CITY OF ALBUQUERQUE
ADMINISTRATIVE APPROVAL (AA)- SITE DEV PLAN AMENDMENT
ROUTING & REVIEW SHEET

APPLICATION #: 14AA-10028	PROJECT #: 1609988
PROJECT NAME: Sandia Research Park	
APPLICANT or AGENT: Cartesian Surveys Inc.	
PHONE # and E-MAIL: 896-3050	
ZONE ATLAS PAGE: M-21	
ADMINISTRATIVE APPROVAL (AA) for:	<input type="checkbox"/> EPC CASE <input type="checkbox"/> DRB CASE

Re: Amended Site Plan to reflect the proposed lot lines and easements.

Site Sketch for
Lots 3-A, 3-B and 3-C, Block 4
Sandia Research Park
Comprised of
Lot 3, Block 4, Sandia Research Park
Located Within Section 33, Township 10 North,
Range 4 East, New Mexico Principal Meridian
City of Albuquerque
Bernalillo County, New Mexico
April 2014

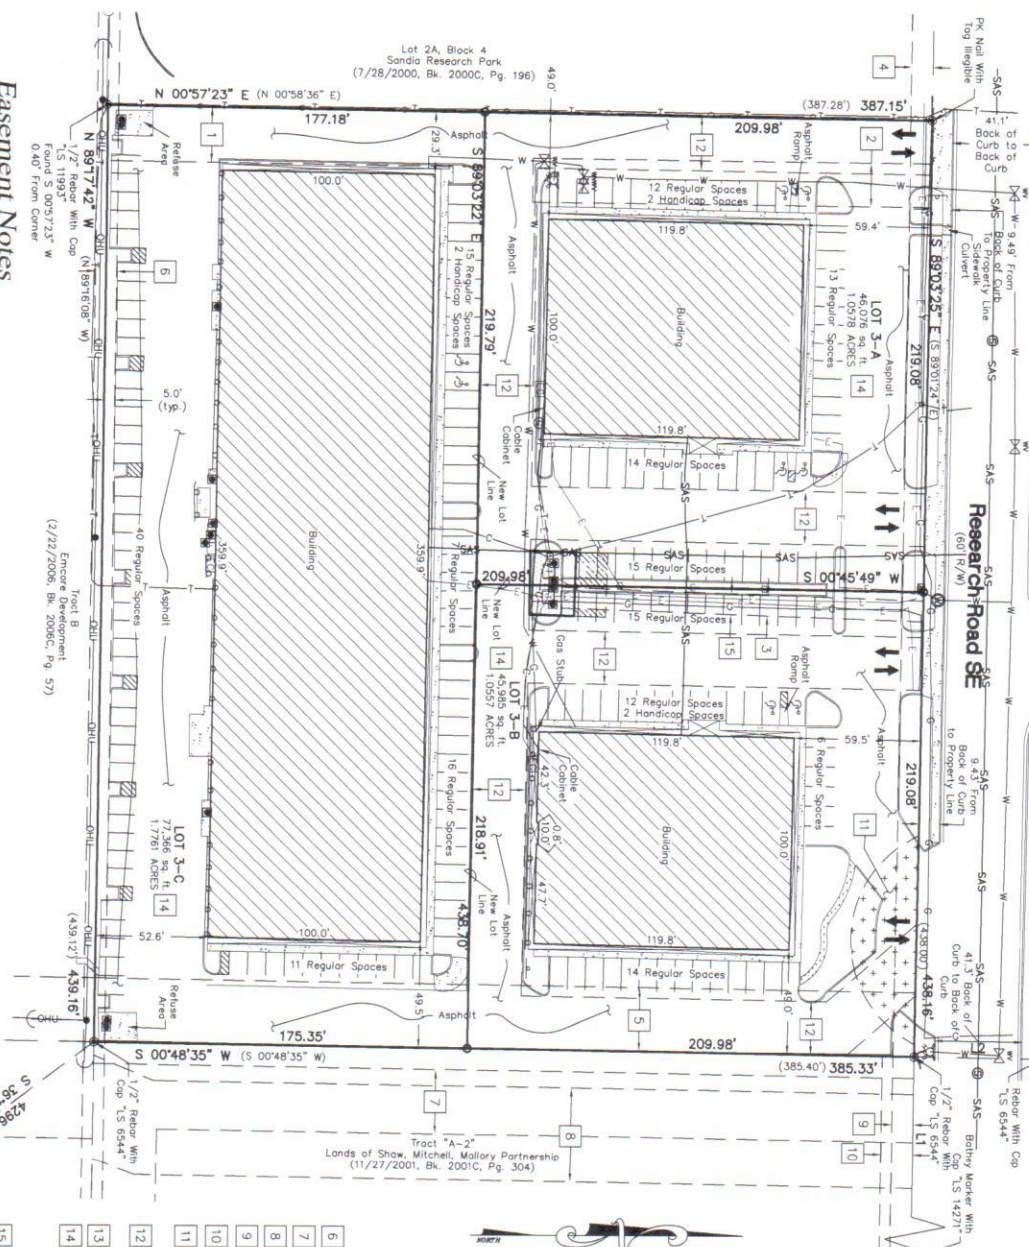
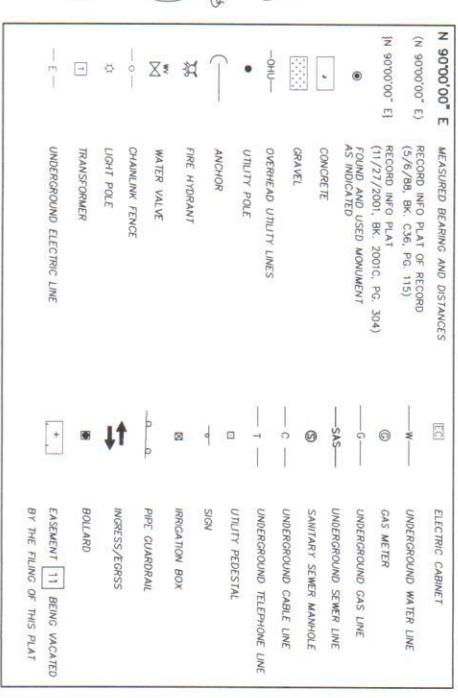
① TRANSPORTATION (505) 924-3630	DATE RECEIVED: 04-09-14
PLANS DISAPPROVED: KOM	DATE: 04/10/14
PLANS APPROVED:	DATE:
COMMENTS:	
(04-10-14) The plat + SPBP will have an infrastructure list tied to approval (IL will include removal of temp turnaround + installation of sidewalk, curb + gutter) - an AA is not appropriate in this instance; it appears that a Site Plan for Subdivision will be required for this site - please clarify; the site plan does not reflect ^{reflect} existing conditions

② UTILITIES (505) 924-3989	DATE RECEIVED:
PLANS DISAPPROVED: AP	DATE: 04/10/14
PLANS APPROVED:	DATE:
COMMENTS:	
Will require either separate accounts for all three lots or shared maintenance for wastewater service.

- Please refer to the Sketch Plat comments issued at the 03-12-2014 Development Review Board hearing. As noted at the hearing, the replat and associated site plan(s) will require an infrastructure list. This infrastructure list must include the removal of the temporary turnaround, curb and gutter, and sidewalk as well as the installation of permanent sidewalk and curb and gutter. As infrastructure is required with this revision, an Administrative Amendment is not appropriate.
- It appears that a Site Plan for Subdivision will be required for this site.
- The site plan shown does not match existing conditions.
